Your ref: SSD 8606 MOD 1
Our ref: MC-17-00001

Request for Comment - Public Exhibition of SSD 8606 - Marsden Park Warehousing and Light Industrial Estate, on Lot 23 & 24 Hollinsworth Road, Marsden Park

ATTACHMENT A

HOLLINSWORTH ROAD
LONGITUDINAL SECTION - SHEET 1

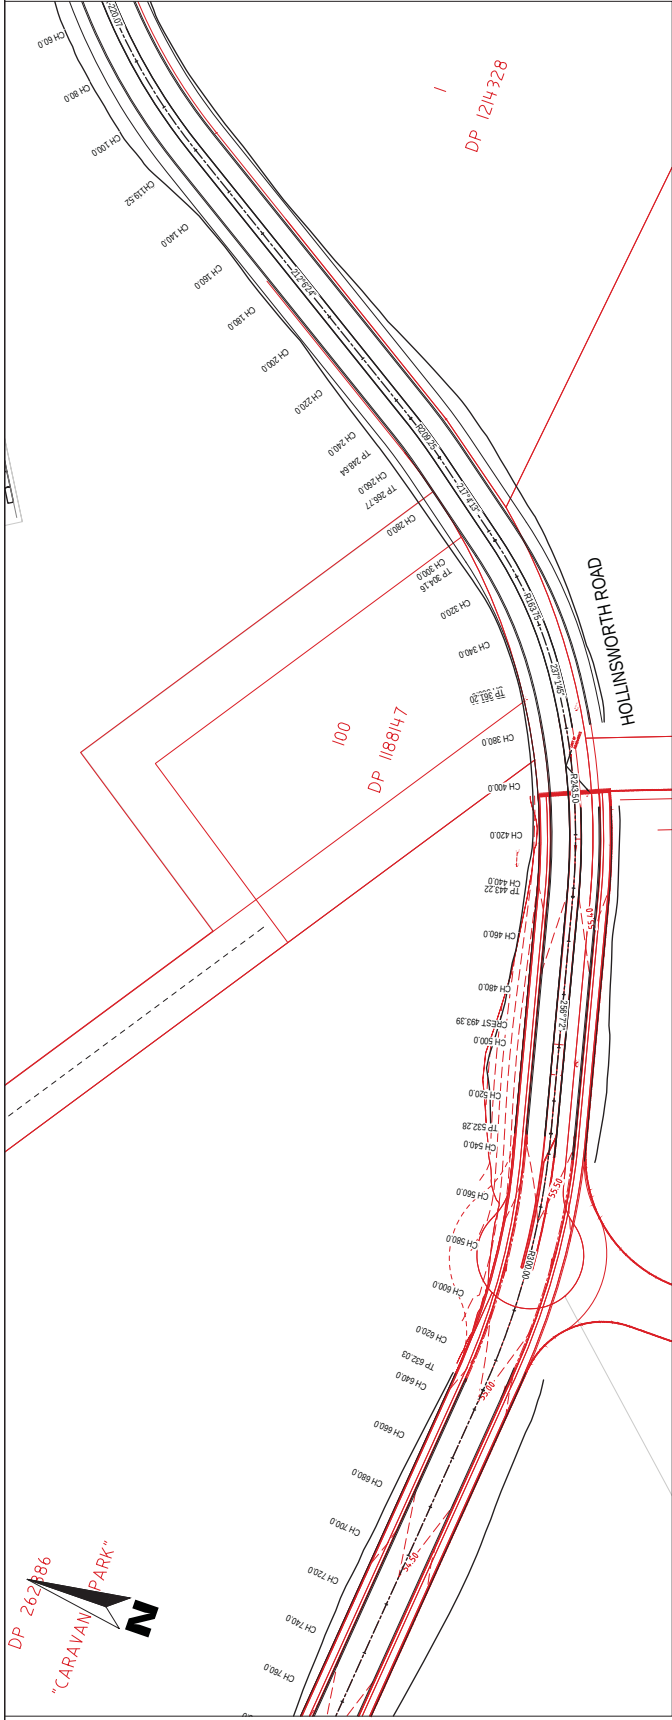
Whilst the modification MOD-17-00050 is still on foot, which proposes amendments to the existing road pattern including the relocation of Hollinsworth Road, and seeks to amend the approved subdivision pattern in DA-15-00275, we maintain that this SSD proposal is premature. Until the final road alignment for Hollinsworth Road is determined, there is no certainty as to the final boundaries of the subject development site.

Under State Environmental Planning Policy (Sydney Region Growth Centres) 2006, Hollinsworth Road is zoned as SP2 Local Road. The applicant has submitted a modification application (MOD-17-00050) which includes in its proposal the realignment of Hollinsworth Road. It is recommended that this SSD proposal should not be determined prior to the determination of the modification application. The proposal is deemed premature and could change given the modification is undetermined. Of particular concern is the final road alignment, and the design of the roundabout providing the main access to this site, which is yet to be determined.
